**Application No: SSD-83258708**  
**Property: 29 Florida Street, Sylvania**  
**Proposal: Construction of 8 residential flat buildings containing a total of 484 dwellings across two stages (including 159 residential apartments for the purpose of affordable housing)**

Thank you for the opportunity to comment on the State Significant Development (SSD) application (SSD-83258708) for the above residential development including affordable housing at 29 Florida Street, Sylvania.

3.3 Precinct Plan — Market Housing 3

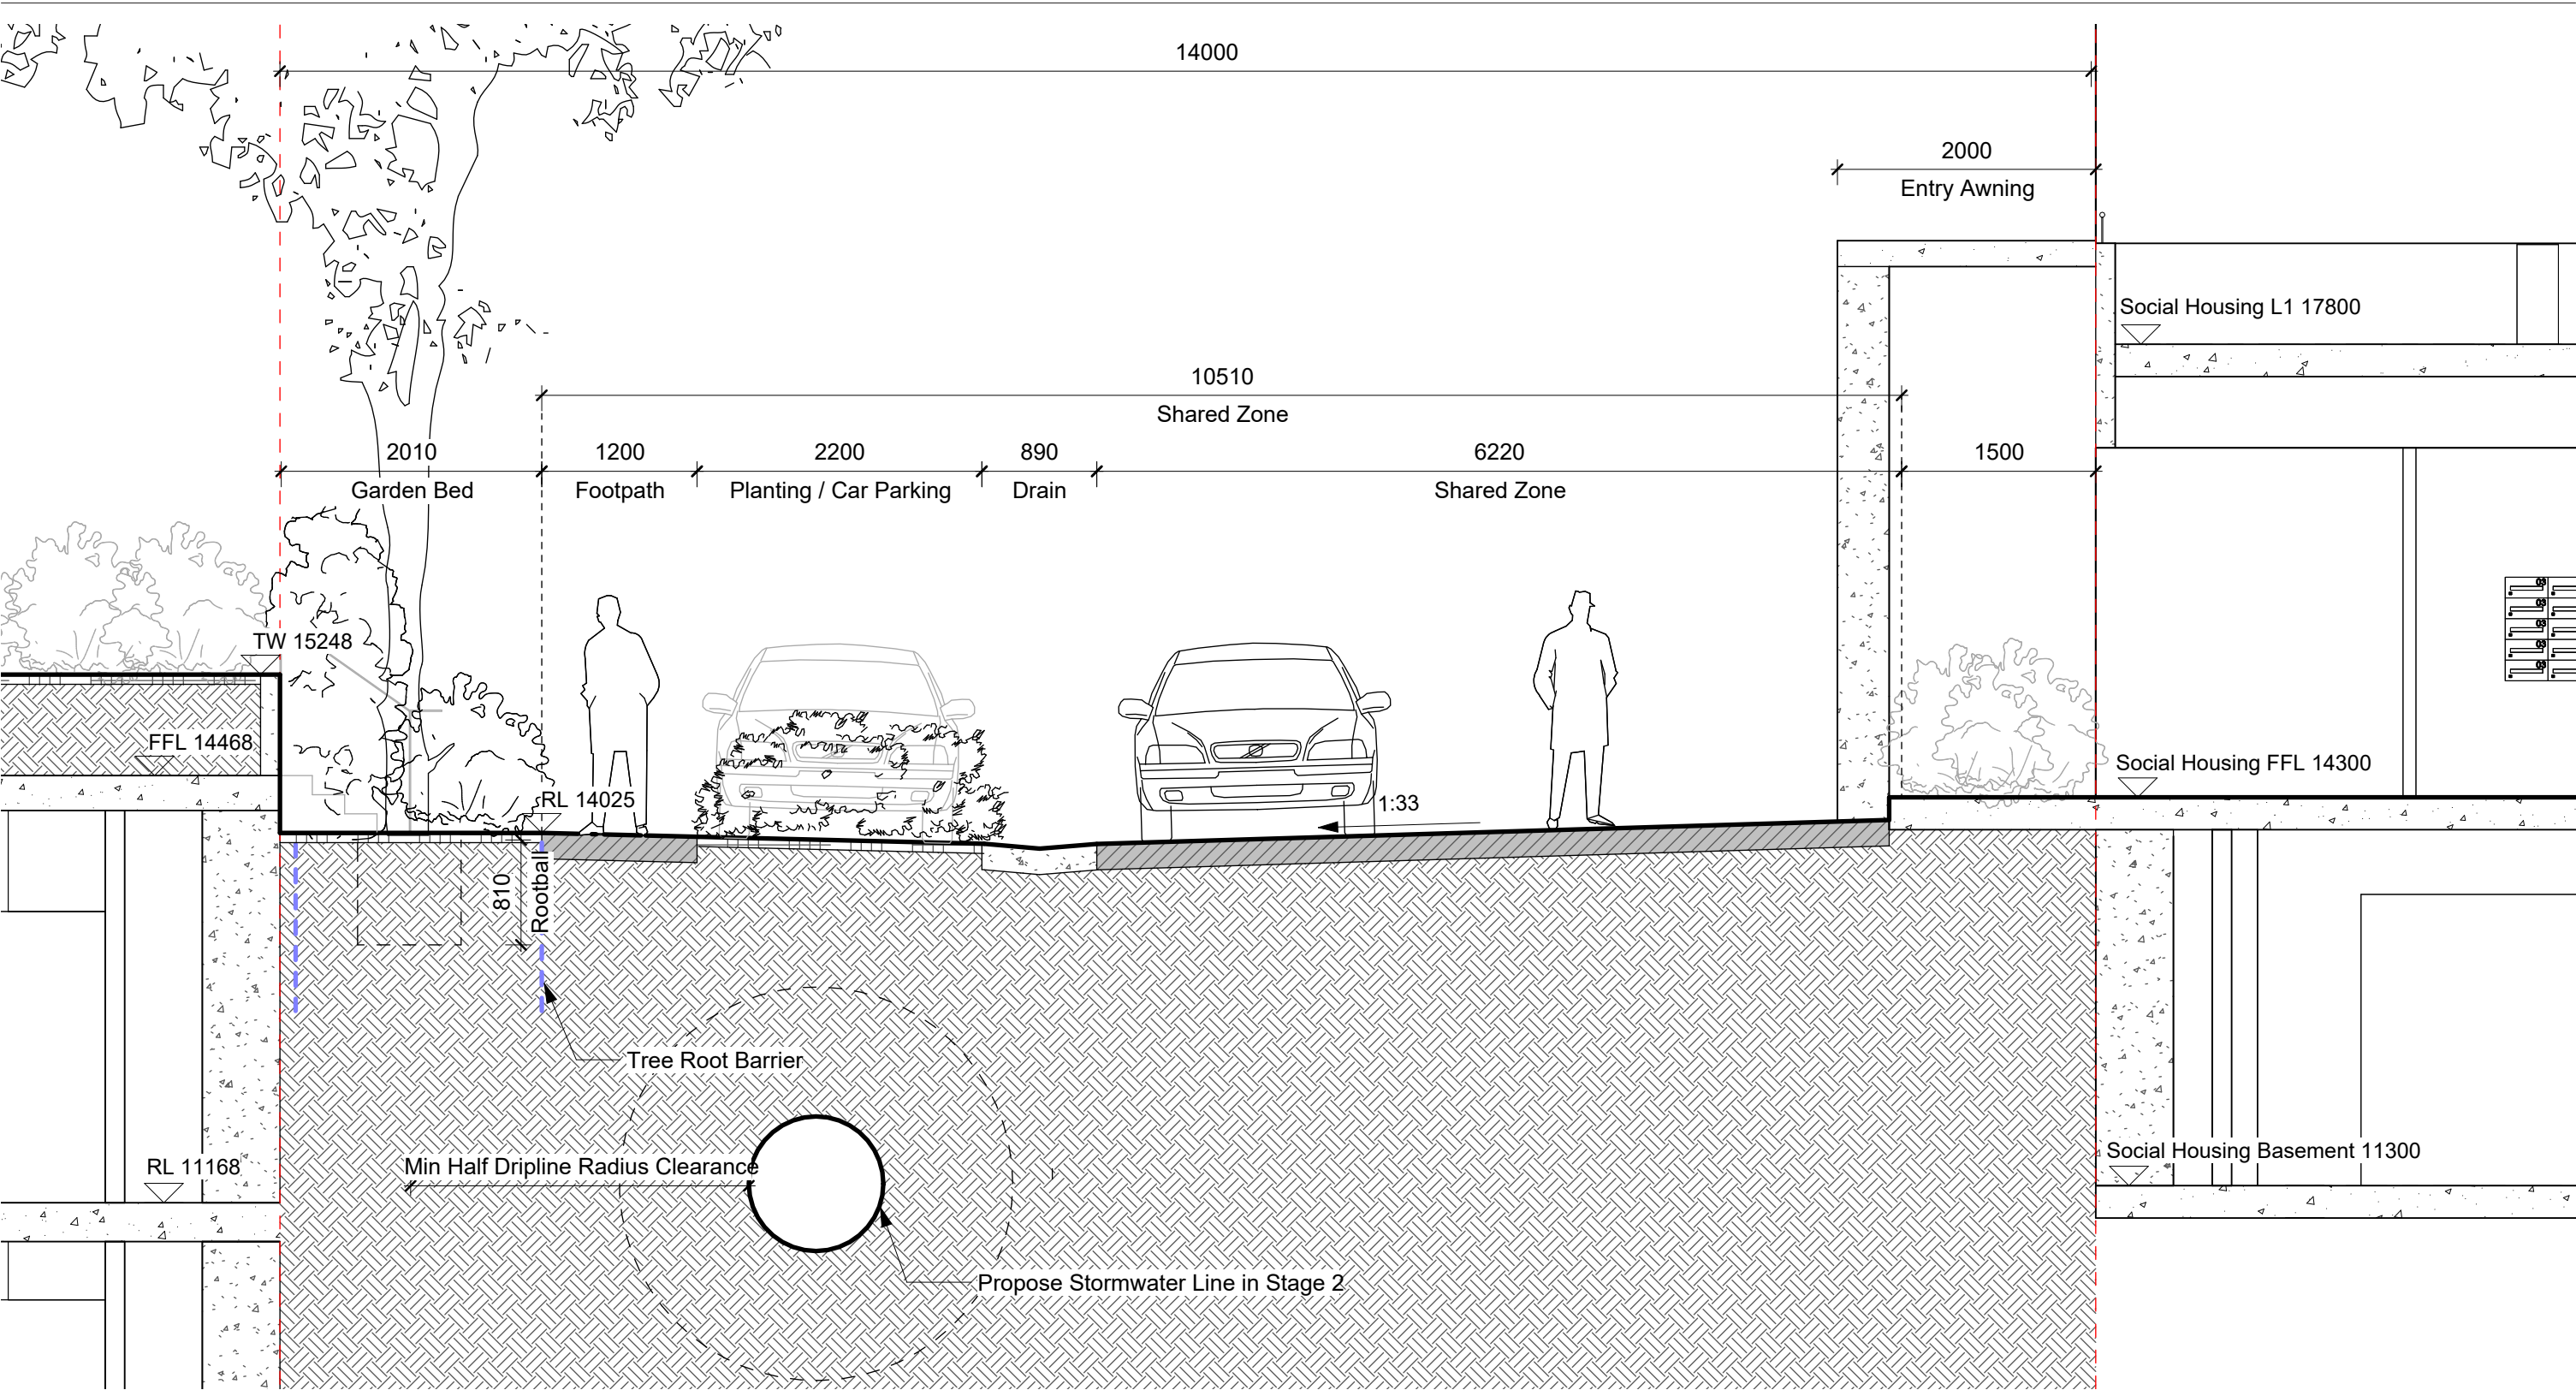
- The outdoor gym equipment is proposed to be accessible to the public 24 hours a day and would therefore be difficult to manage. Its location within a narrow space between buildings 3A and 3B, and in close proximity to windows of habitable rooms, is likely to result in adverse privacy and amenity impacts for residents. Consideration should be given to relocating the gym to a more appropriate location, such as within the ground floor of a residential building, where access can be controlled and the facility effectively managed. The western edge of building 3 may provide a suitable alternative location.

- The pedestrian path located within the landscape setback to Port Hacking Road provides limited amenity value and has the potential to compromise the privacy of adjoining residential units. There is an opportunity to utilise this setback as a landscaped buffer rather than a pedestrian thoroughfare, which would improve residential amenity, enhance visual screening, and better respond to the interface with Port Hacking Road.

Map 14 - 1% AEP - Design Scenario - Flood Hazard

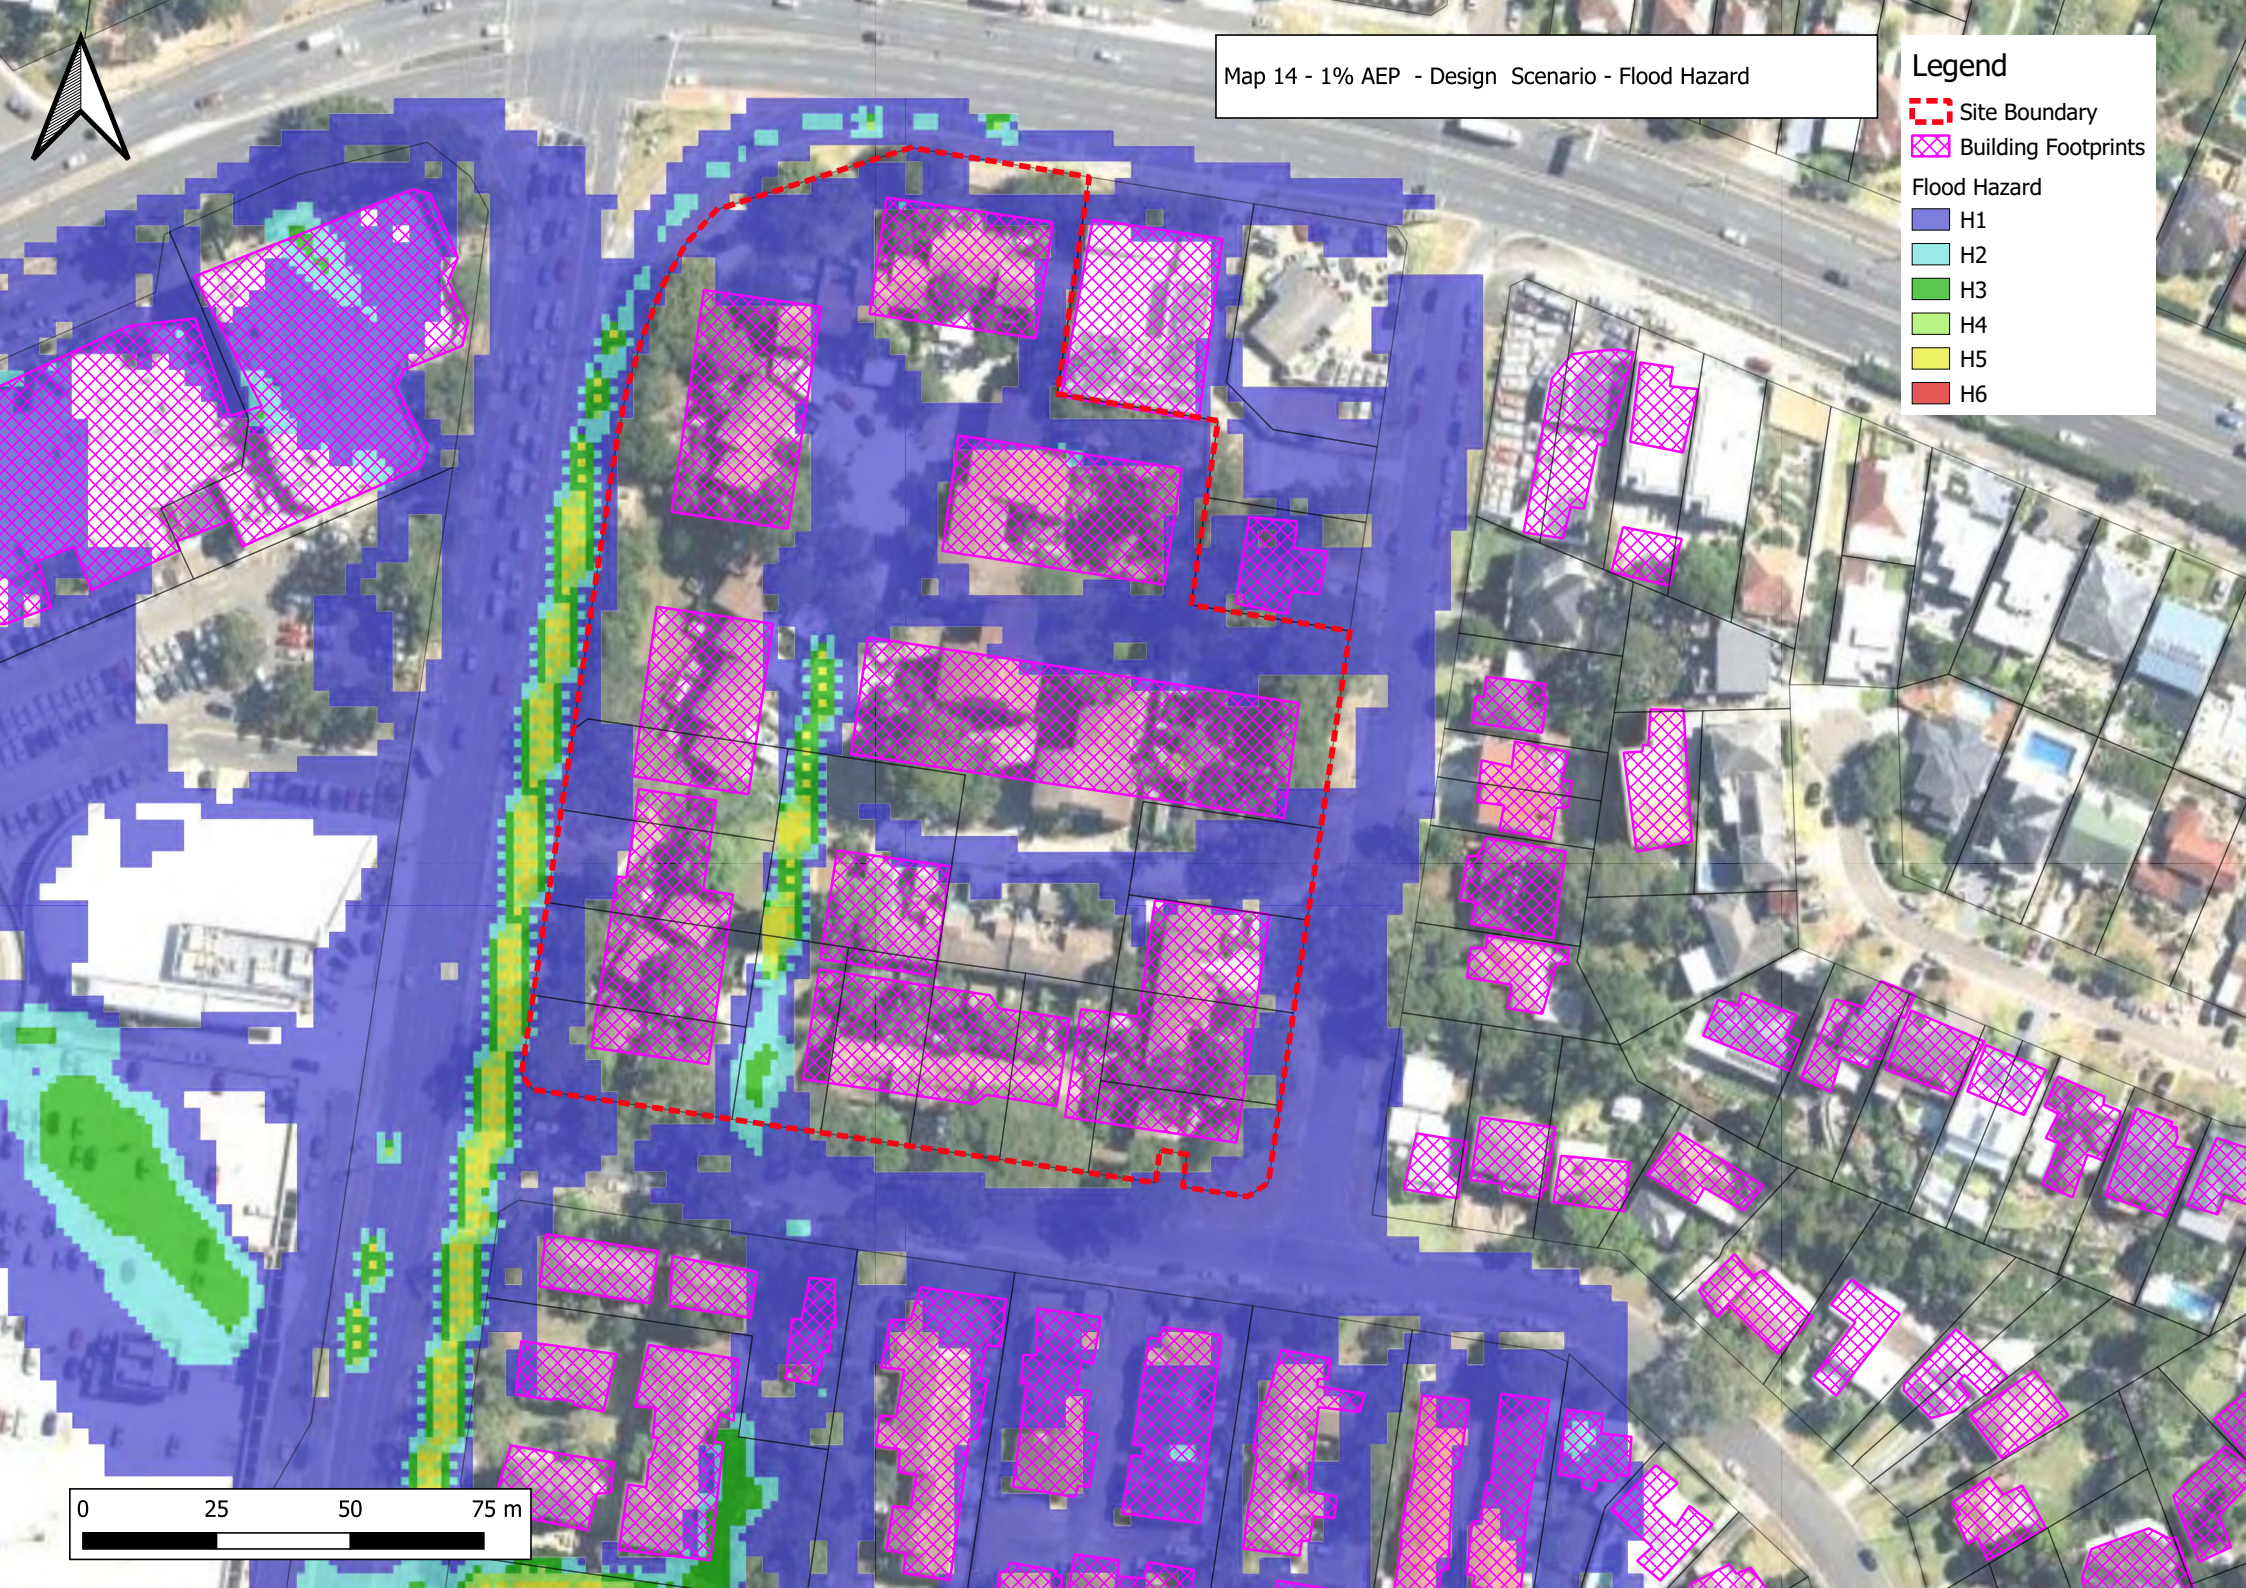
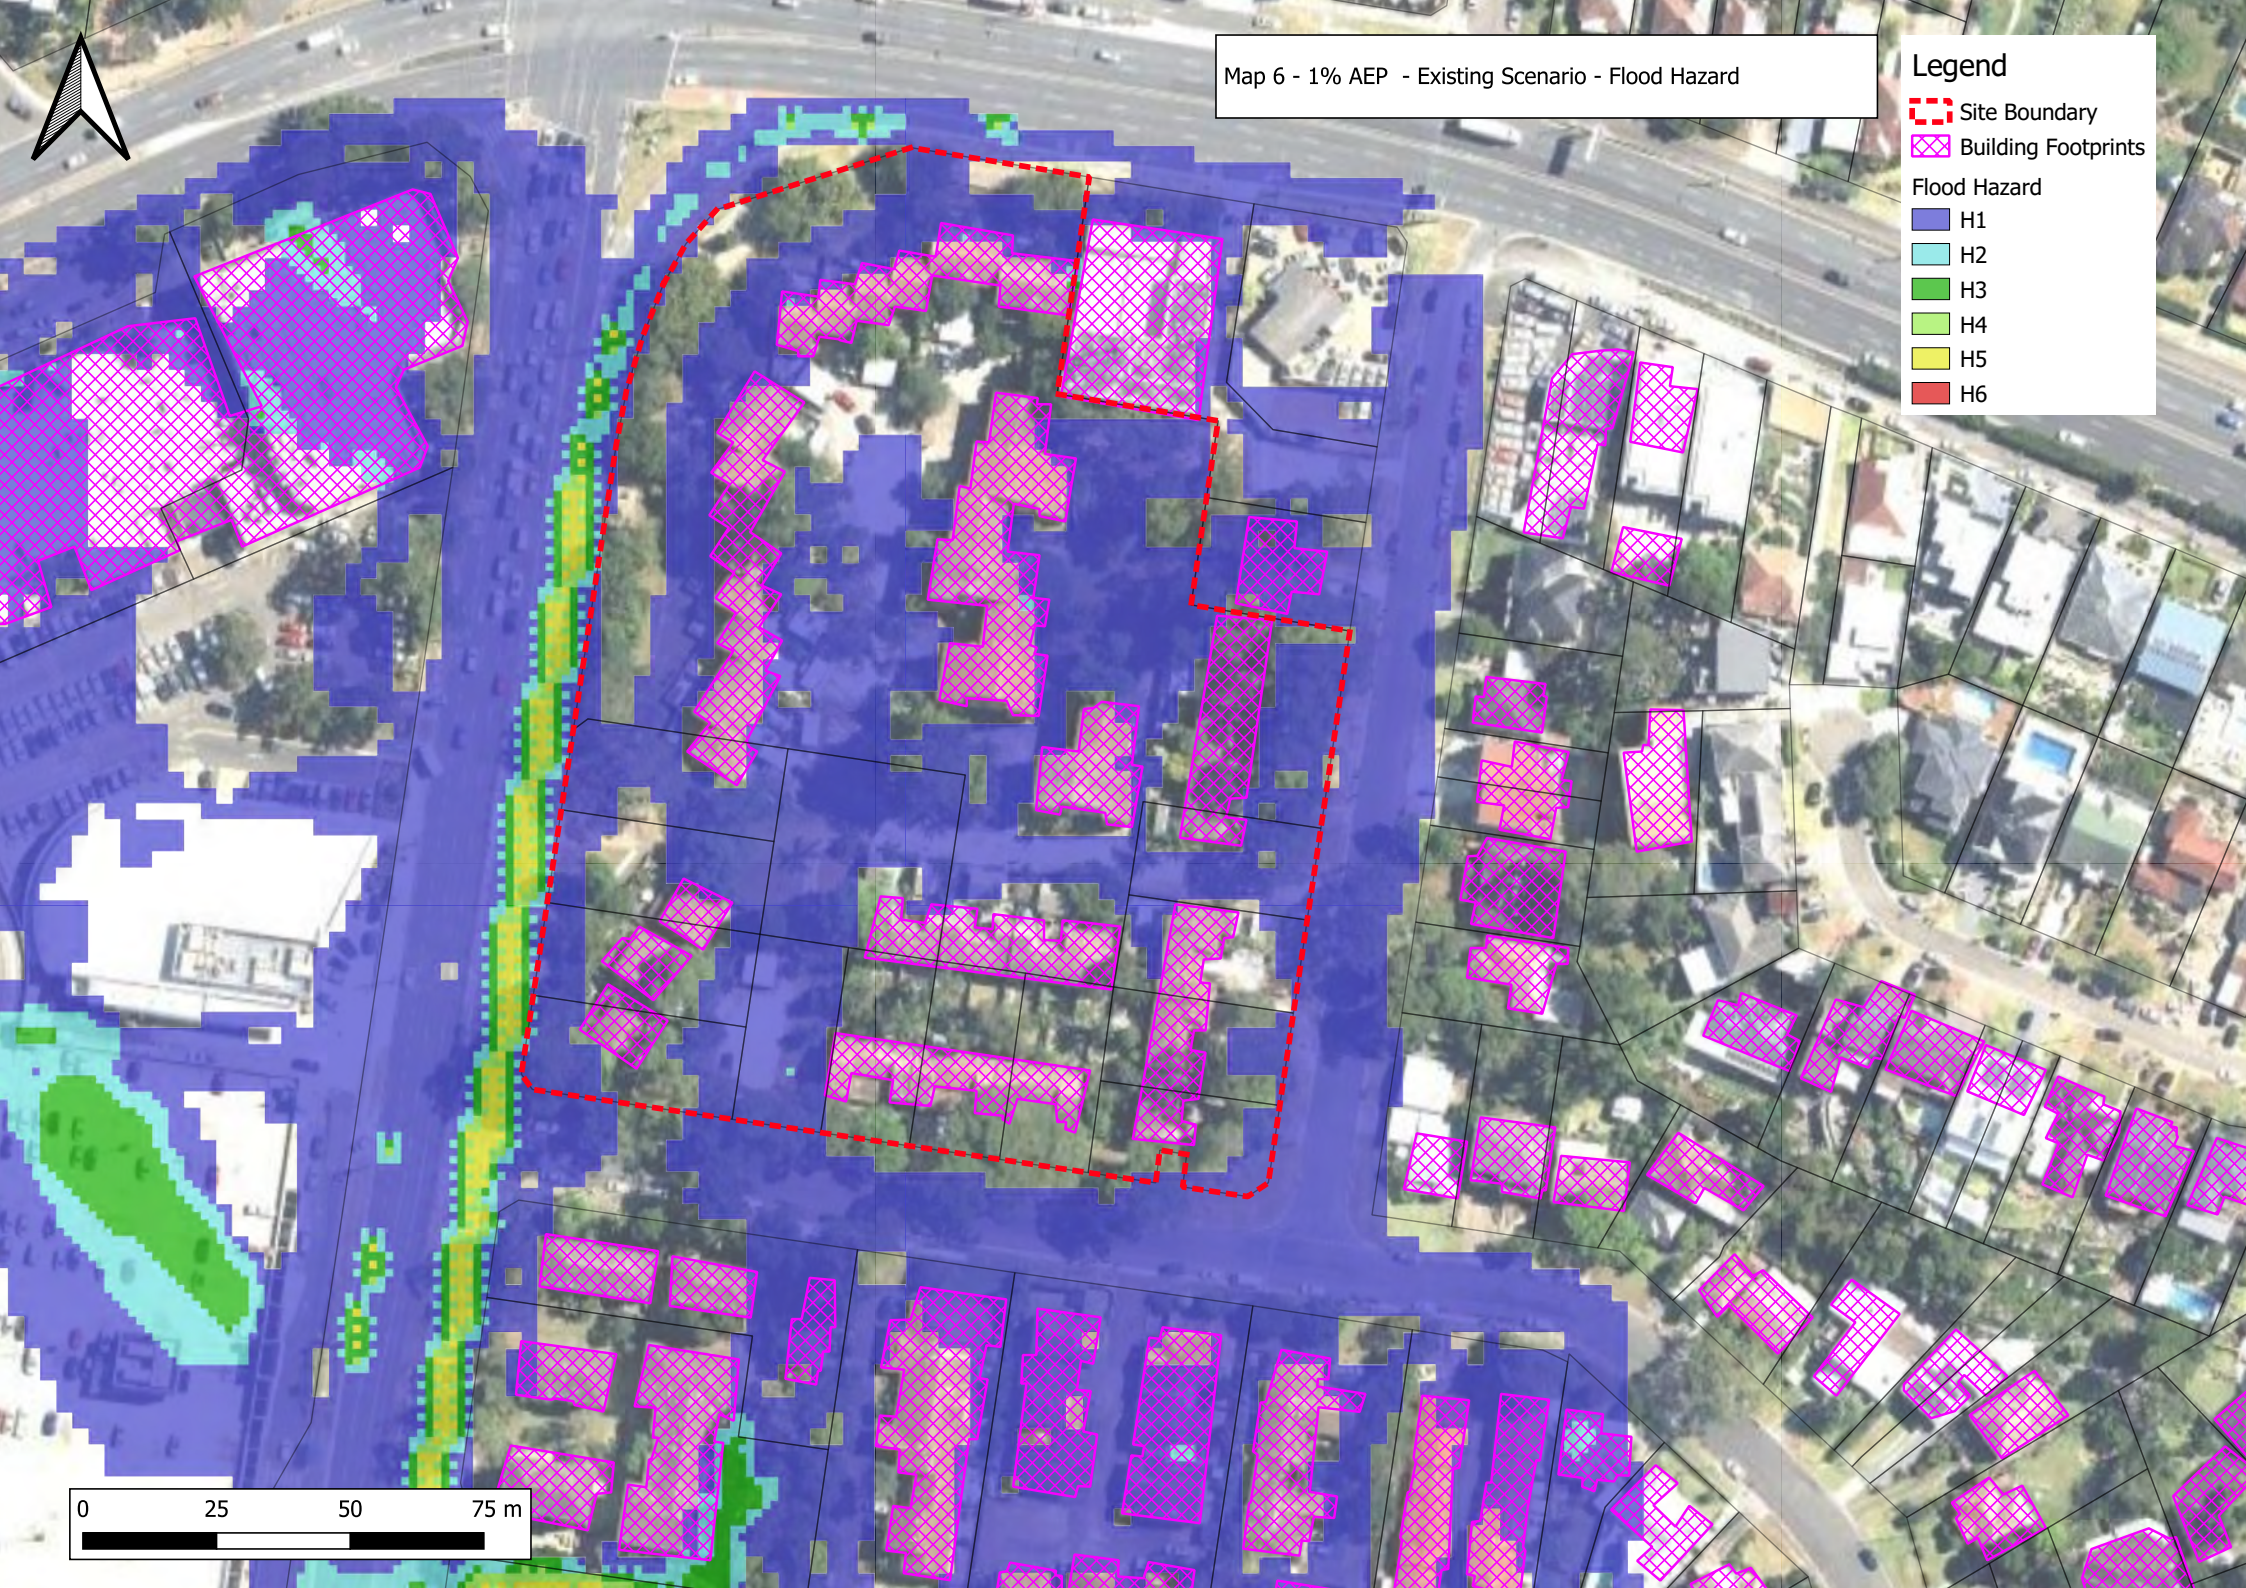
- Basement crests are to be individually assessed and provided where required. The crest must achieve the minimum 500mm freeboard.
- The increase in flood hazard at the intersection of Pembroke Street and the Private Road rating to H5 hazard is not acceptable. Flood mitigation works is required to ensure that the existing rating is not increased.
